Lime Down

Solar Park

Written Summary of the Applicant's Oral Submissions and Responses at Issue Specific Hearing 3 and Responses to Action Points

Document Reference: EXAM/9.50

Title:
Figure 13-5 Abnormal Load Routes - Solar PV Sites

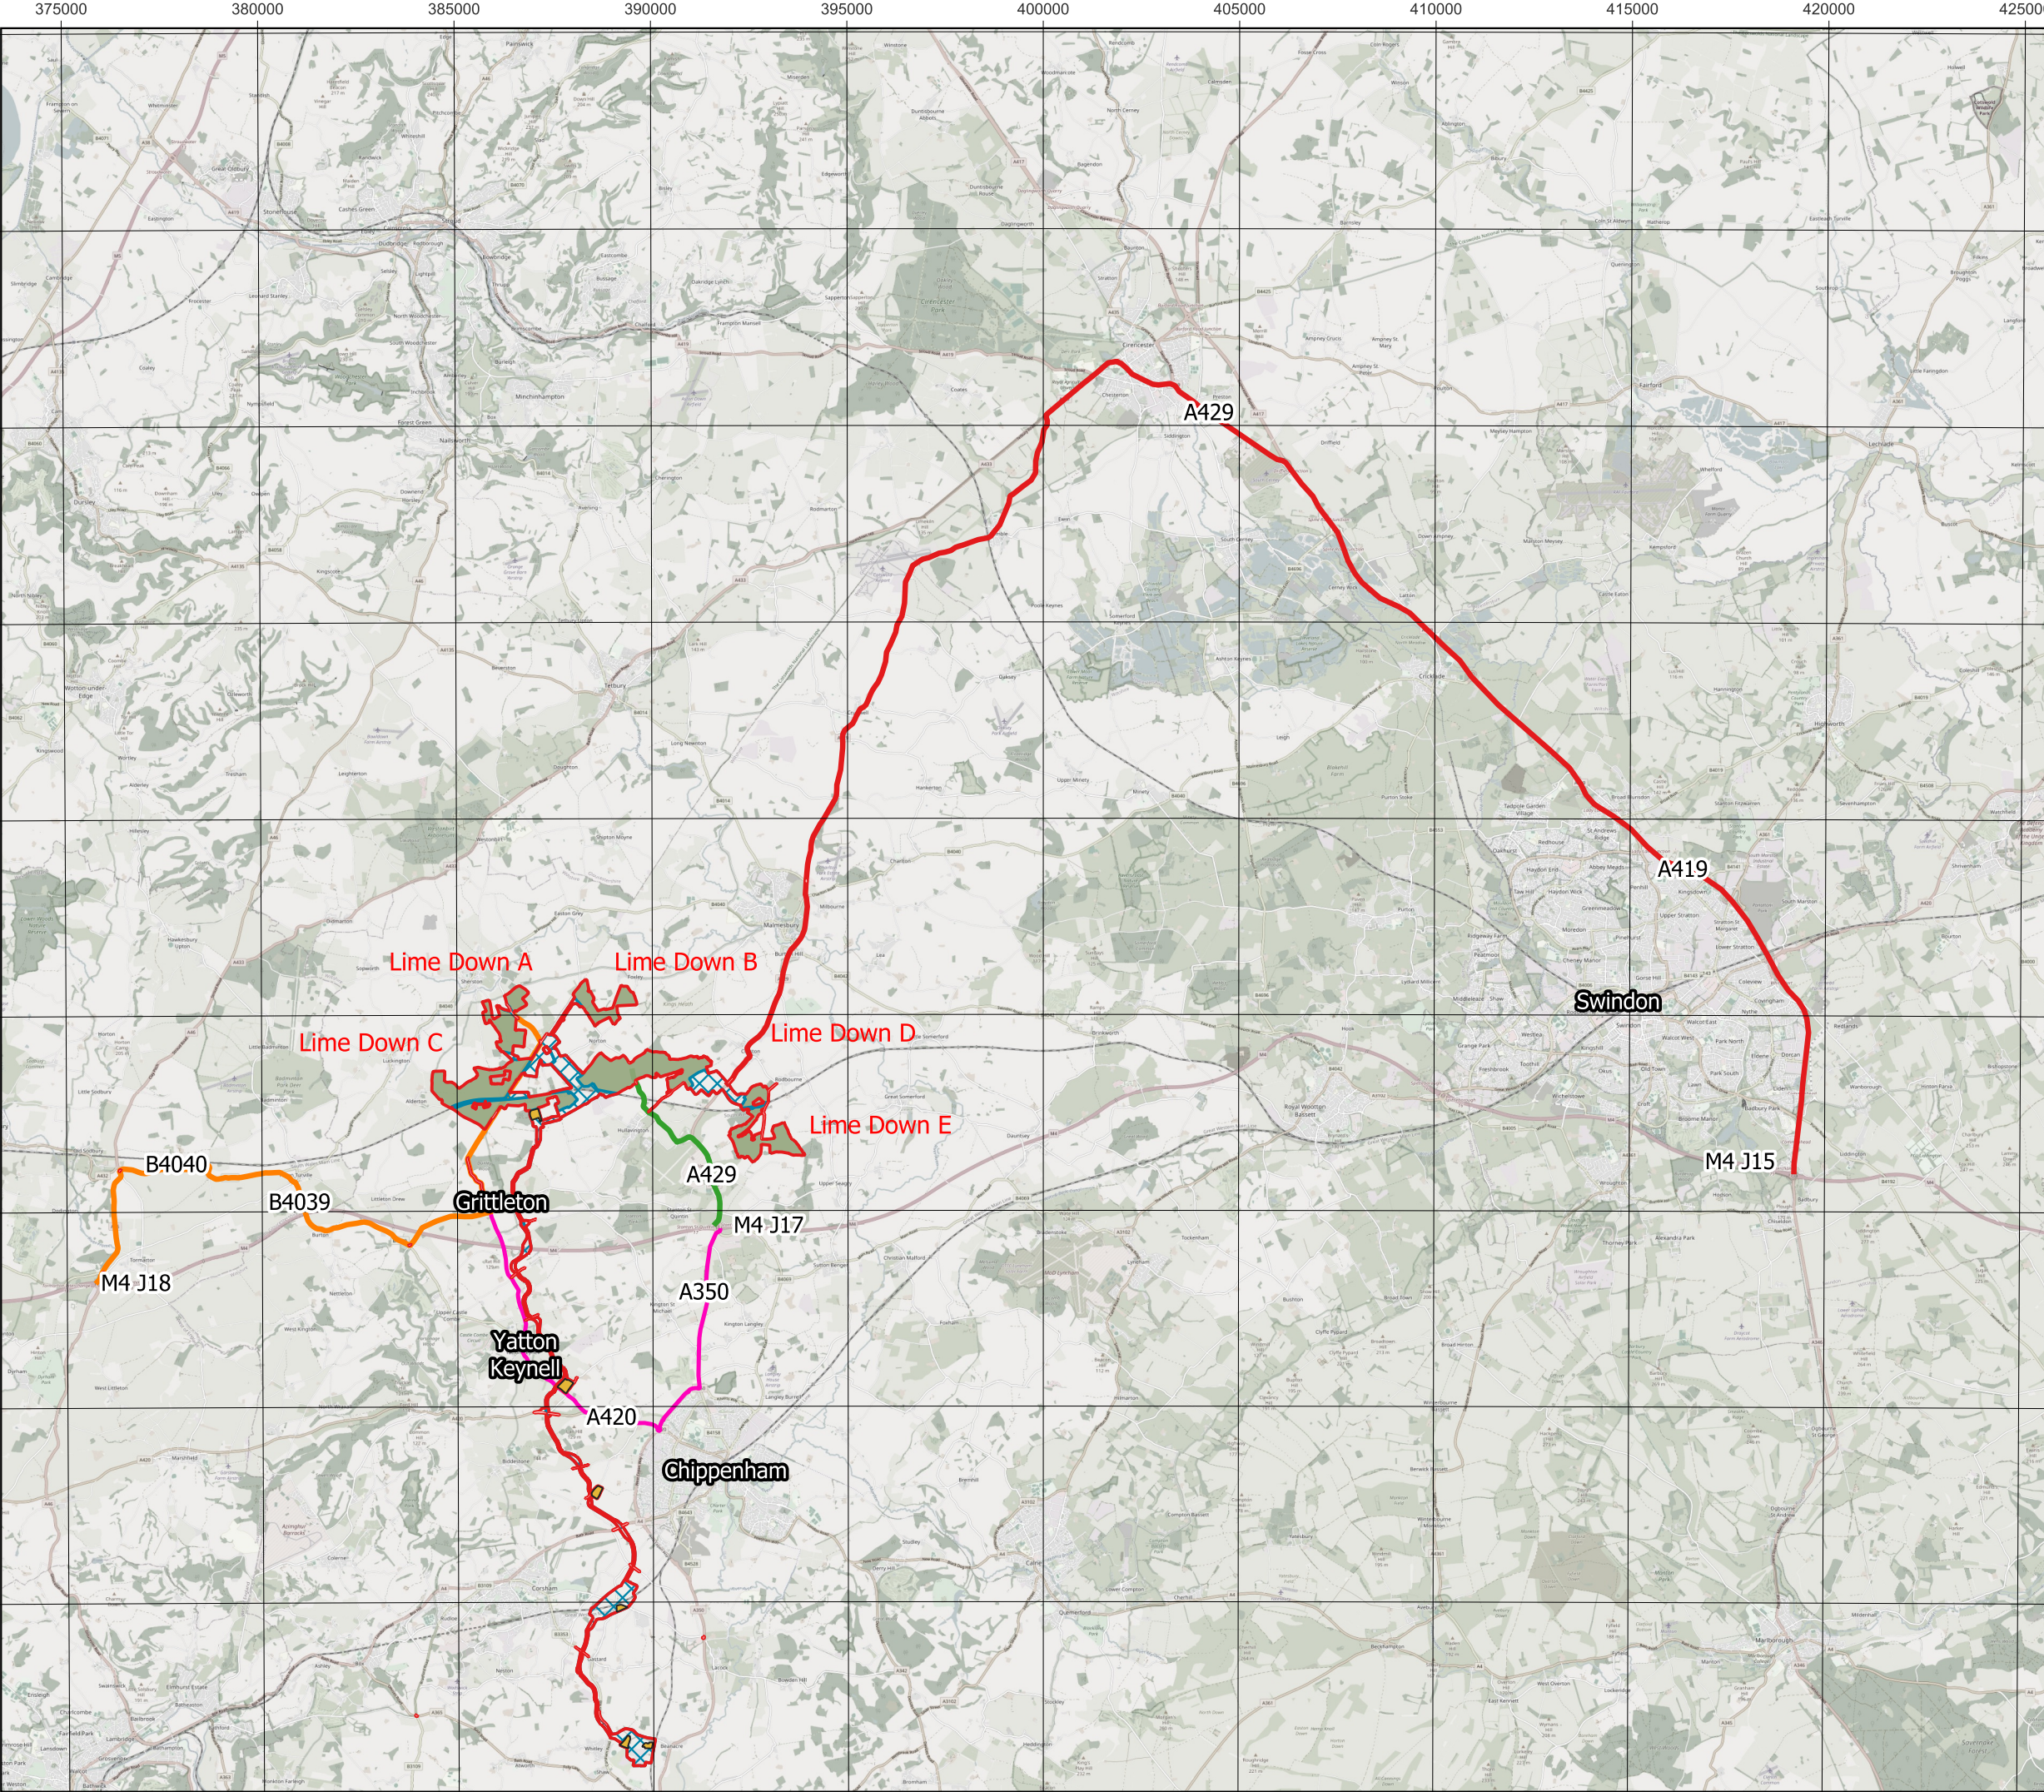
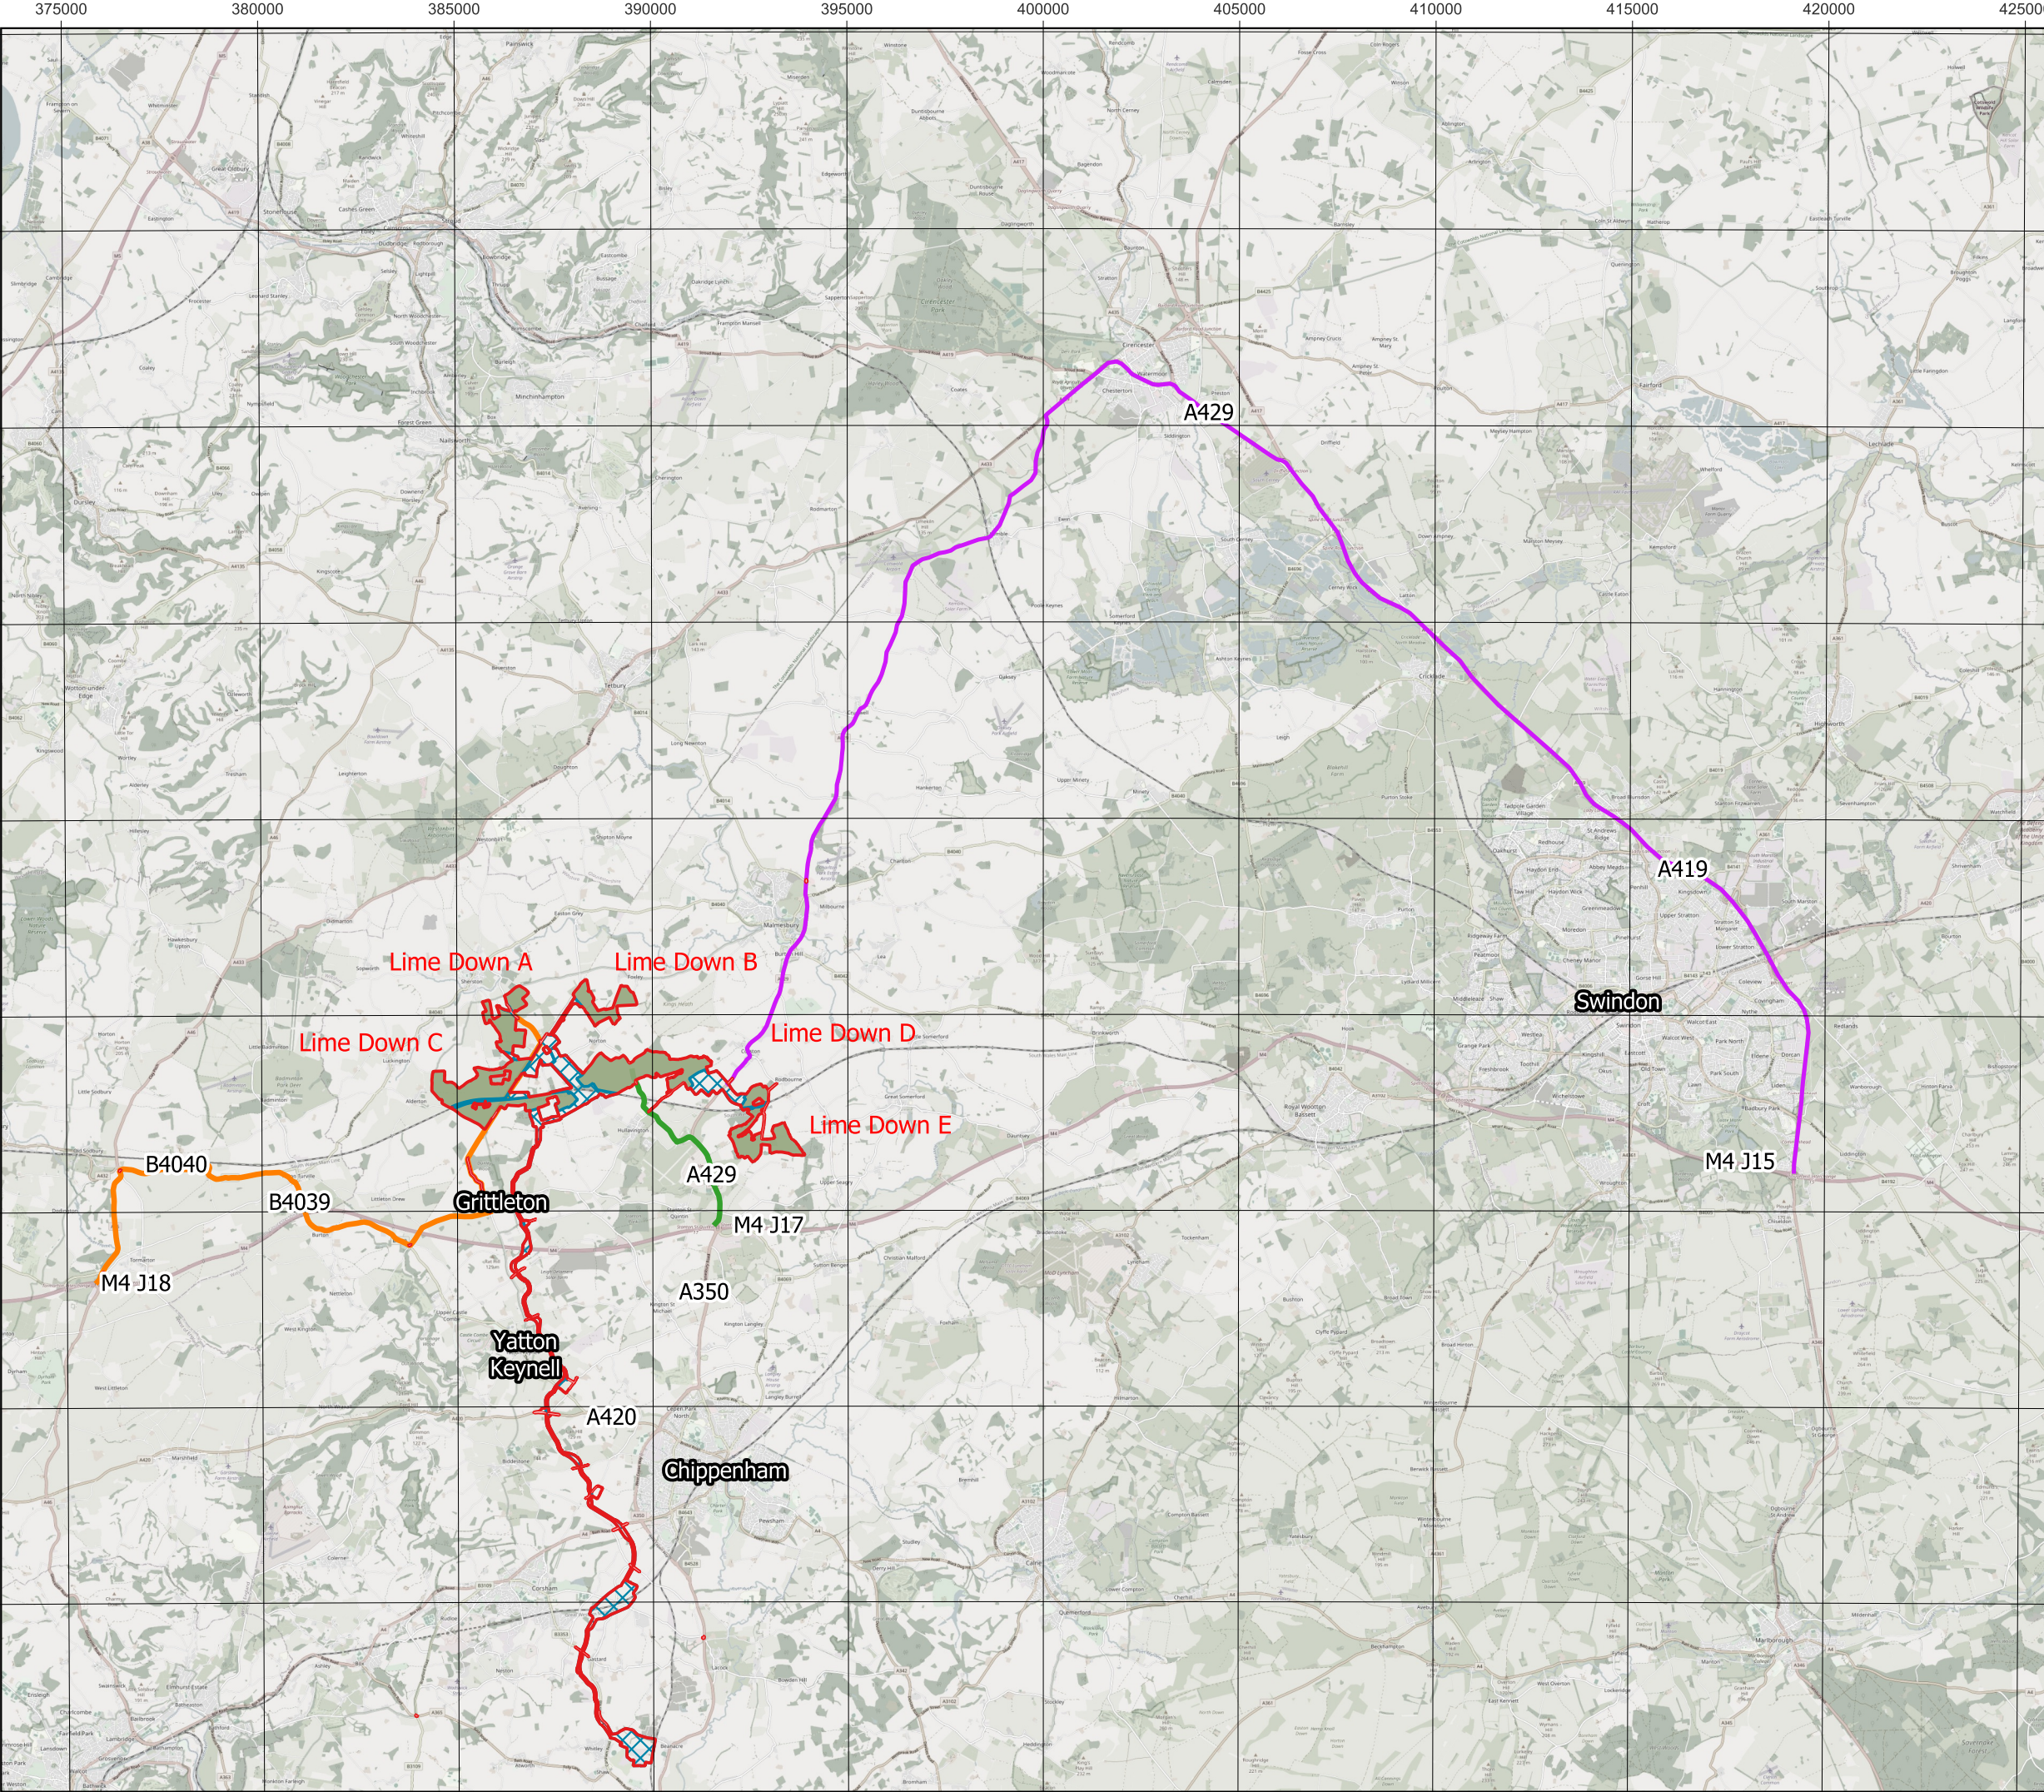
Agenda item	Comment
	Mitten and gave evidence that the development would generate traffic within the national landscape and expressed concern that it would exceed the 10% tranquillity threshold, which is Rule 2 from the IESB guidelines. Insufficient information was said to have been provided on transport modelling to demonstrate the 10% threshold would not be breached. Stop Lime Down maintained that transport is an important element of tranquillity and that whilst construction is temporary, the 2-year period represents a significant environmental impact. Reference was made to Section 10, [REP1-172], where the previous inspector's decision is discussed. Odette Chalaby on behalf of Wiltshire Council agreed there will be a significant impact on the Cotswolds National Landscape. From a highways perspective, the routes selected are suitable in context and there is no radically better alternative solution. The Council's greater concern was how to manage traffic appropriately. Mr Darrall confirmed that the example stated by Mr Bamber and included in [REP1-172] related to a 500-unit housing development, sited in the CNL that would result in a permanent increase in traffic, so was not comparable. Mr Darrall confirmed the tranquillity note has been submitted and a further note is to be provided which will consider noise as a result of traffic. The ExA raised specific construction route location queries and referred to ES Volume 2, Figure 13-5 Abnormal Load Routes - Solar PV Sites [APP-150] showing the main AIL construction routes to the solar PV sites. The Outline Construction Traffic Management Plan (CTMP) [REP3-108] contains details of the AIL construction plans for Routes 1–4. The orange route (Route 1) runs from M4 junction 18 along the A46 north to the B4040 at Old Sodbury, then B4039 towards Grittleton, Alderton Road, and the Fosse Way. <i>Post Hearing Note:</i>

3.	Applicant	Plan [APP-150] to be corrected, as currently shows Lime Down A and C substation AIL route (Alternative) going through Yatton Keynell.	Deadline 4	Addressed in the post hearing note at agenda item 2.1 of this written summary.

Agenda item	Comment
	<i>ES Volume 2, Figure 13-5 Abnormal Load Routes - Solar PV Sites [EN010168/APP/6.2] (Revision 2) has been updated and submitted at Deadline 4. In addition, the AIL route numbering for Solar PV Sites has been updated at paragraph 1.7.11 of ES Volume 3, Appendix 13-1: Transport Assessment [EN010168/APP/6.2] (Revision 4) and at paragraph 5.3.1 and Appendix D of the Outline CTMP [EN010168/APP/7.22] (Revision 4) submitted at Deadline 4.</i> However, on page 122 of the Outline CTMP [REP3-108] it states that after leaving the M4 Junction 18 on the A46, instead of traveling north to Old Sodbury and taking the B4040, an alternative route would take vehicles from the A46 to the B4039 via Acton Turville Road and Tormarton Road. The Applicant demonstrated the route on screen by cursor. The ExA asked at what point an alternative route would be considered. Mr Darrall confirmed the haulage company was given another option but concluded the orange route is the most suitable, with the haulage company determining the appropriate vehicle type. The ExA noted that if the alternative route is to be retained as an option, it should be shown on the construction route plans or annotated on the plans, rather than being described in writing only, so it can be seen and assessed by other parties. Ms Brodrick on behalf of the Applicant confirmed they would take this point away and, if the alternative route remains, would update the plan accordingly; if not, the wording would be updated to remove the reference. <i>Post Hearing Note:</i> <i>ES Volume 2, Figure 13-5 Abnormal Load Routes - Solar PV Sites [EN010168/APP/6.2] (Revision 2), the Outline CEMP [EN010168/APP/7.22] (Revision 4) and ES Volume 3, Appendix 13-1: Transport Assessment [EN010168/APP/7.22] (Revision 4) has been updated to remove the route between Tormarton and Acton Turville. The alternative AIL route through Yatton Keynell has also been removed.</i>
